# KITTTITAS COUNTY COMMUNITY DEVELOPMENT SERVICES

RE: VA-19-00001 Berlin – Deem Incomplete and Request for Additional Information

Kittitas County Community Development Services (CDS) received a request for a Zoning Setback Variance on February 28, 2019 to reduce the rear yard setback to 10' from 25' for the construction of a single family residence. The subject property is zoned Residential. This parcel is located at 50 Kitzbuhel Place, in a portion of Section 15, T22N, R11E, WM in Kittitas County, bearing Assessor's map number 22-11-15-050-0005. Your application has been determined incomplete and additional information is required.

Sheet Name:
Site Plan

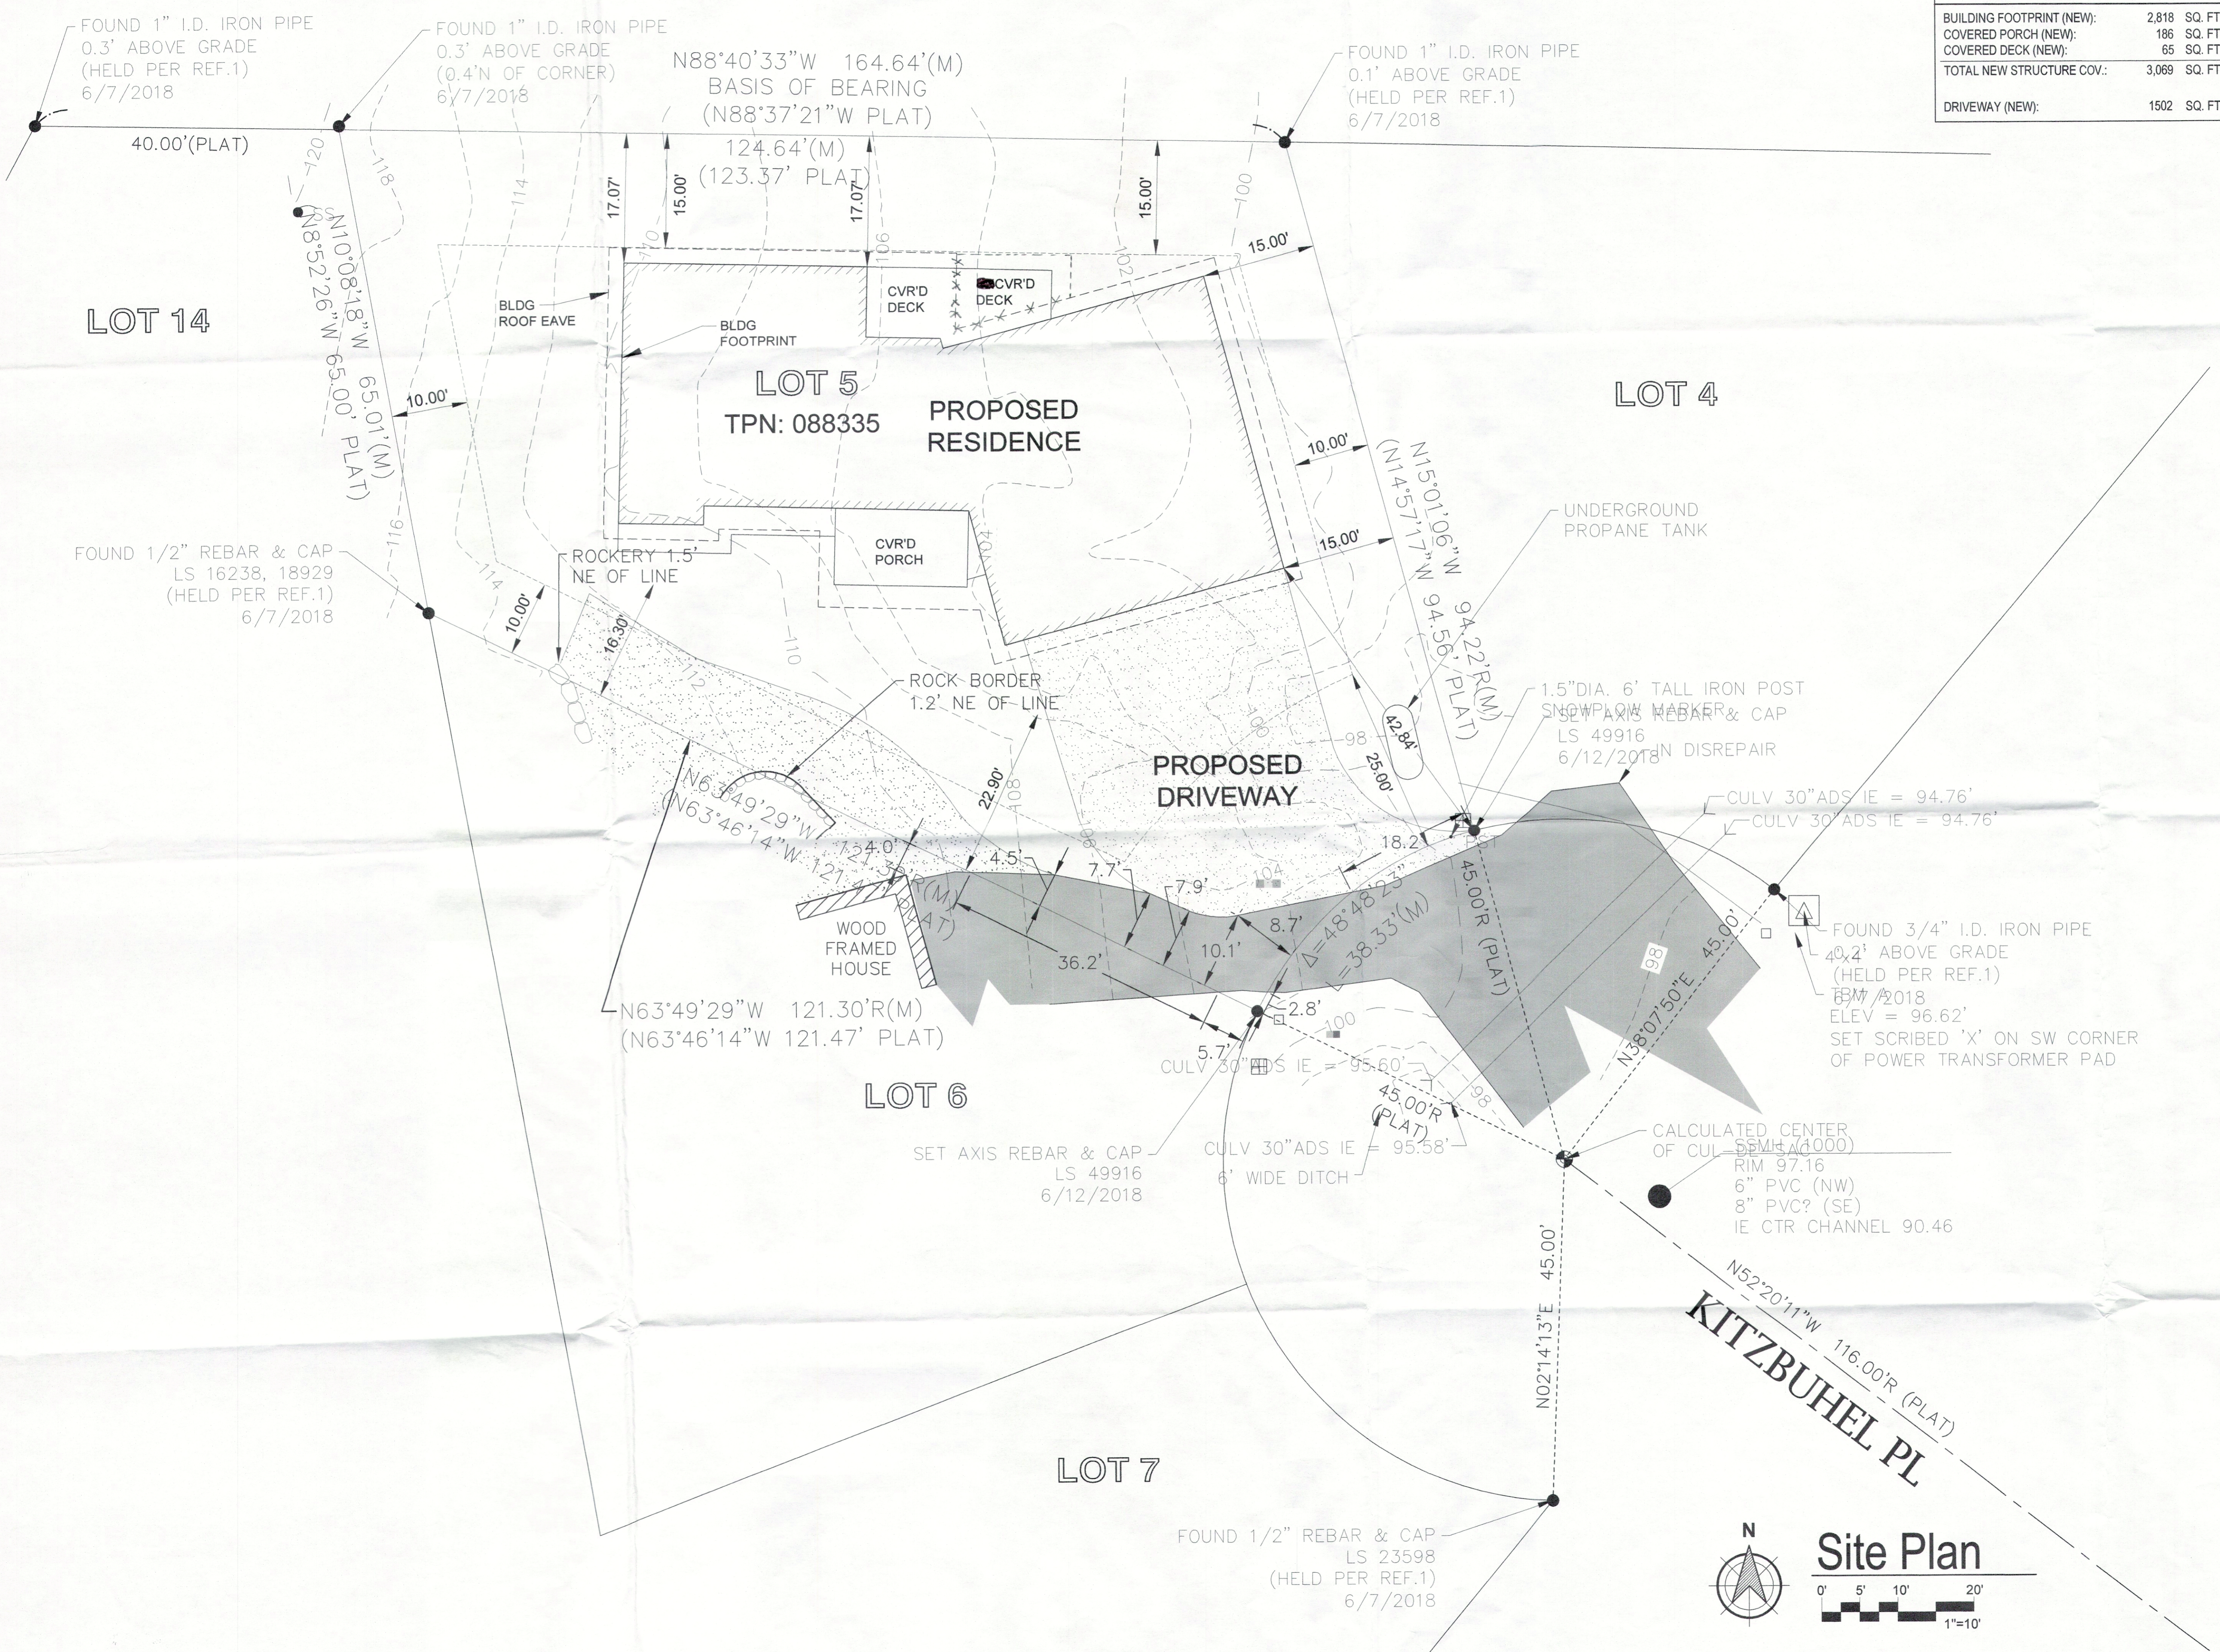
1. A revision to the site plan depicting the square footage of the proposed structure, in order to determine the proposal's consistency with the comprehensive development pattern of the area pursuant KCC 17.84.010(4) above.
2. A revision to the site plan depicting the existing setbacks under current code, and the setbacks (including reduction) for the proposed development so that CDS may review the *“proposed use and its relationship to surrounding properties”*, pursuant to KCC 15A.03(2) above.

TOPOGRAPHIC & BOUNDARY SURVEY
OF
LOT 5 HYAK ESTATES DIVISION 1
(50 KITZBUHEL PL)

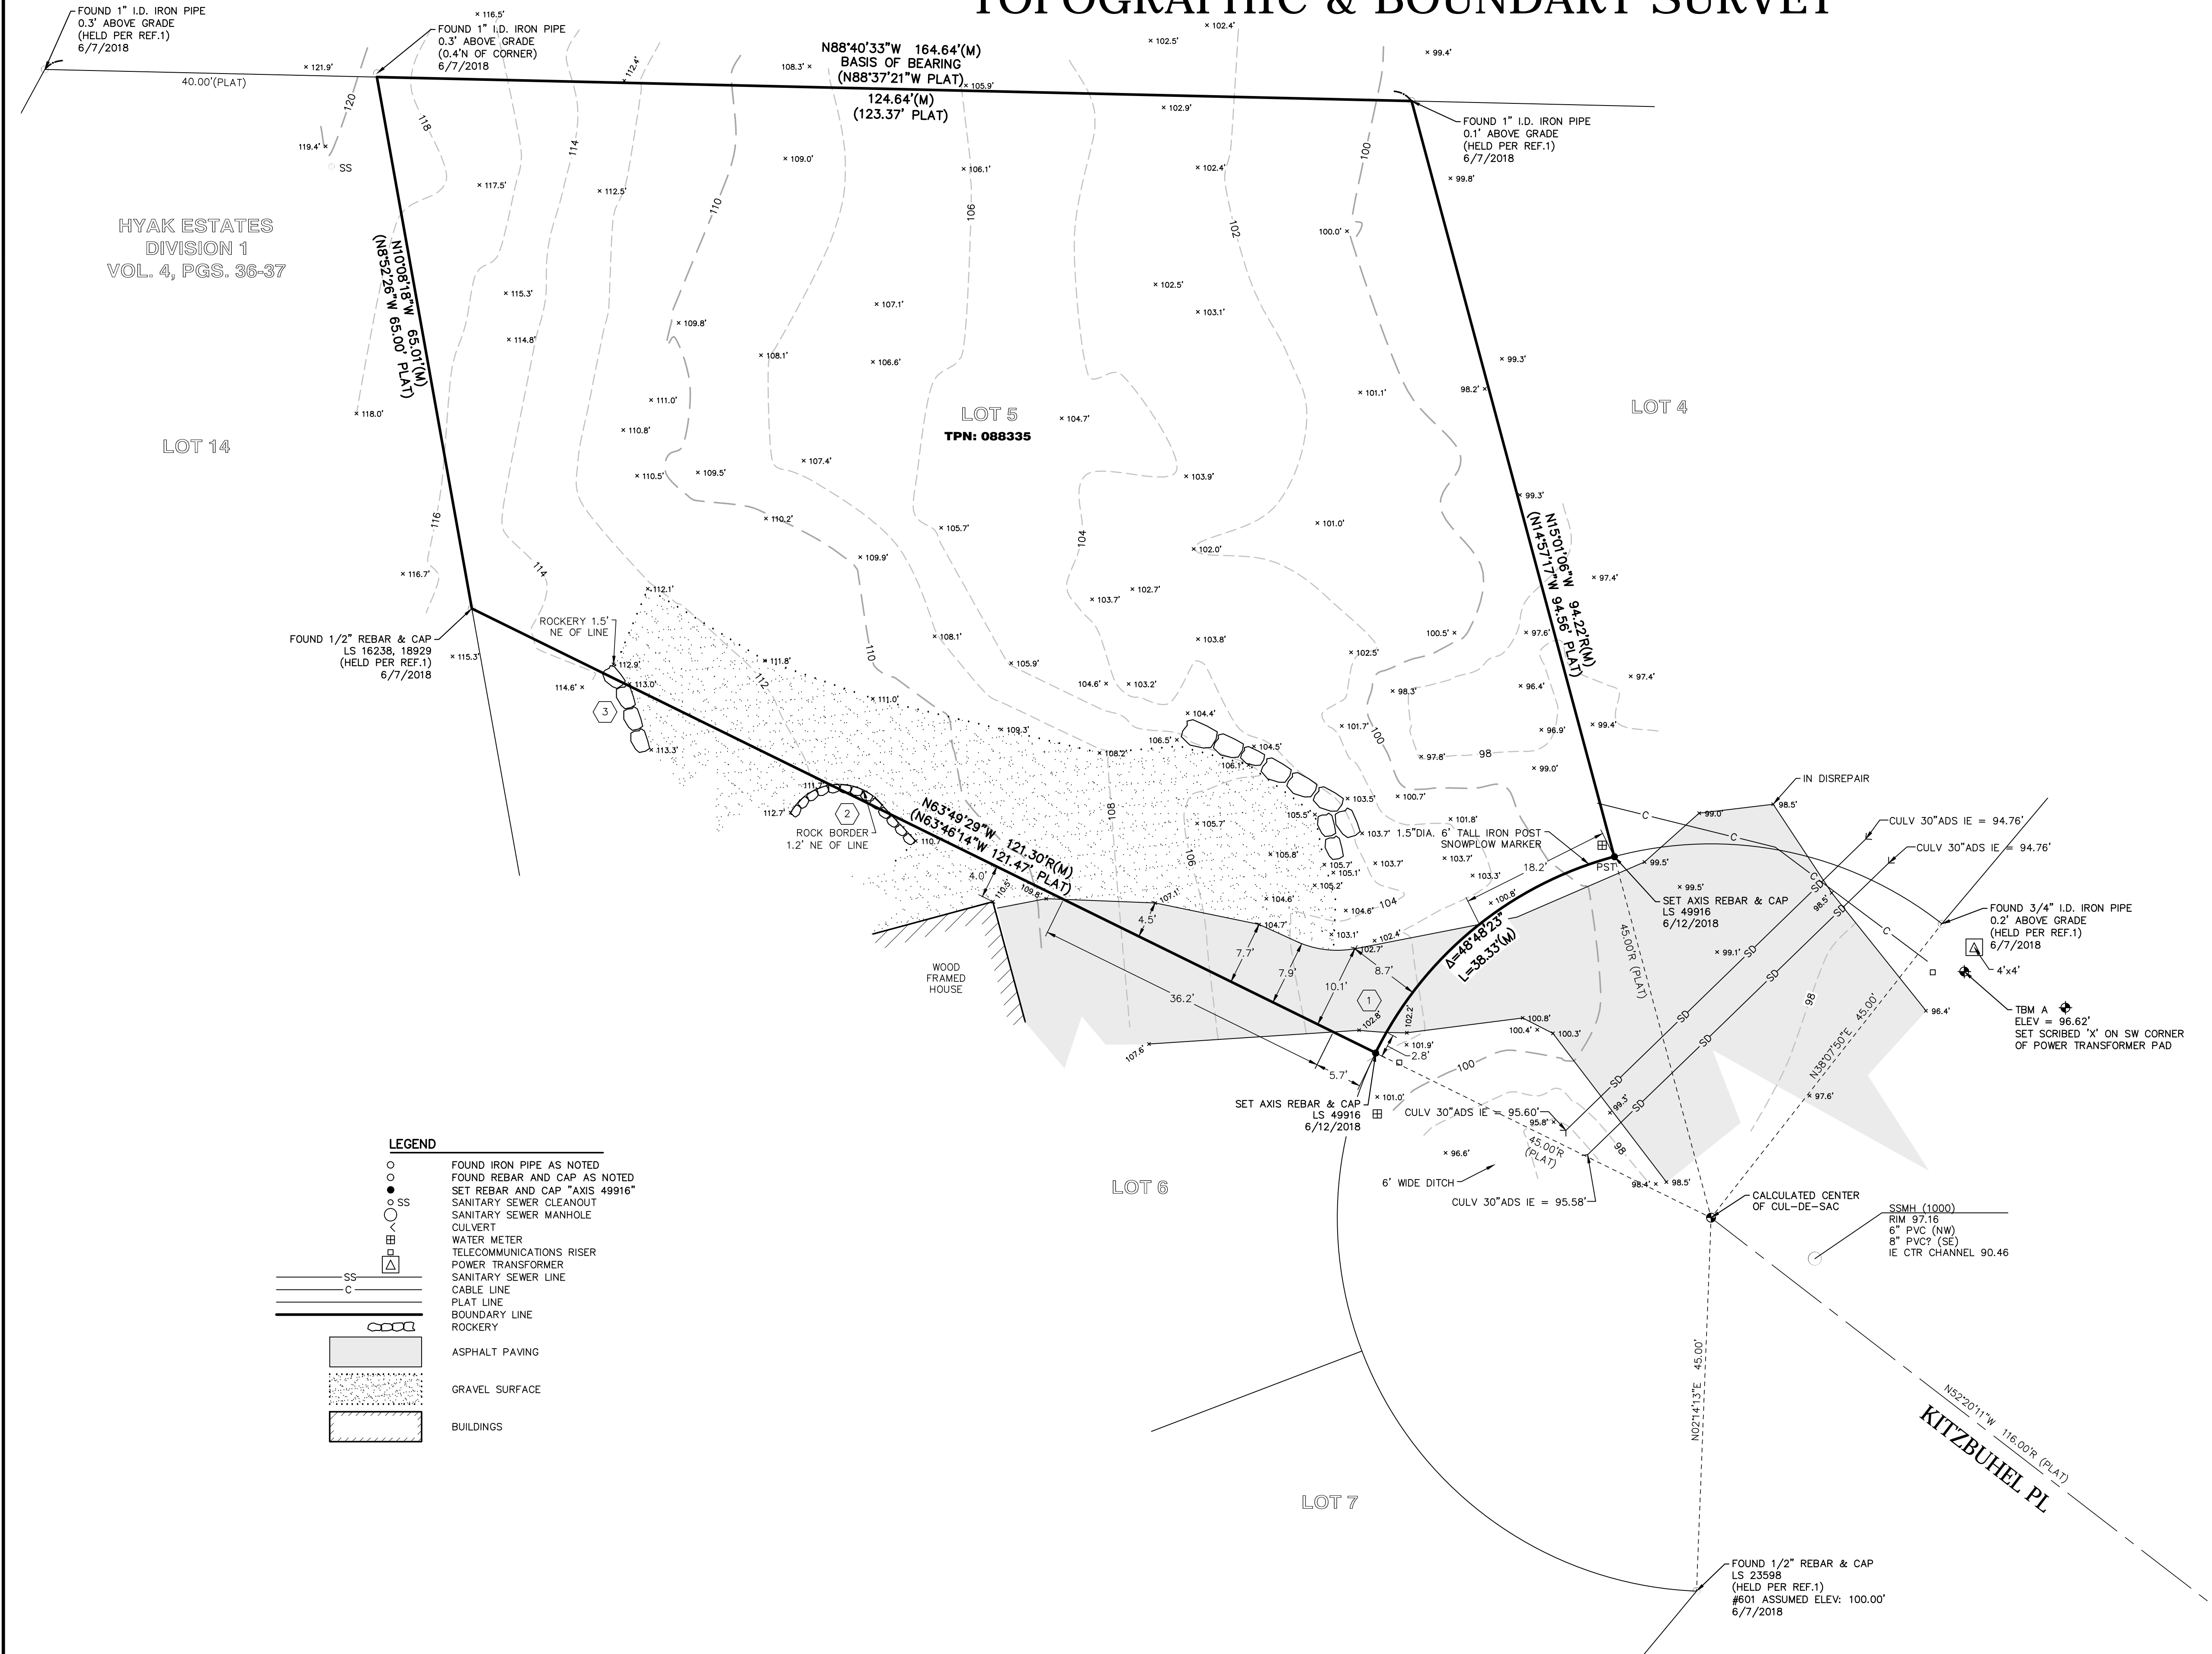
3. Provide additional information regarding the neighbor's "encroaching" driveway and rockery, also pursuant to KCC 15A.03.030(2). Was this "encroachment" discovered by a professional surveyor? If so, please provide a copy of the survey. Is there an existing easement for the driveway and rockery in question? If so, please provide documentation.
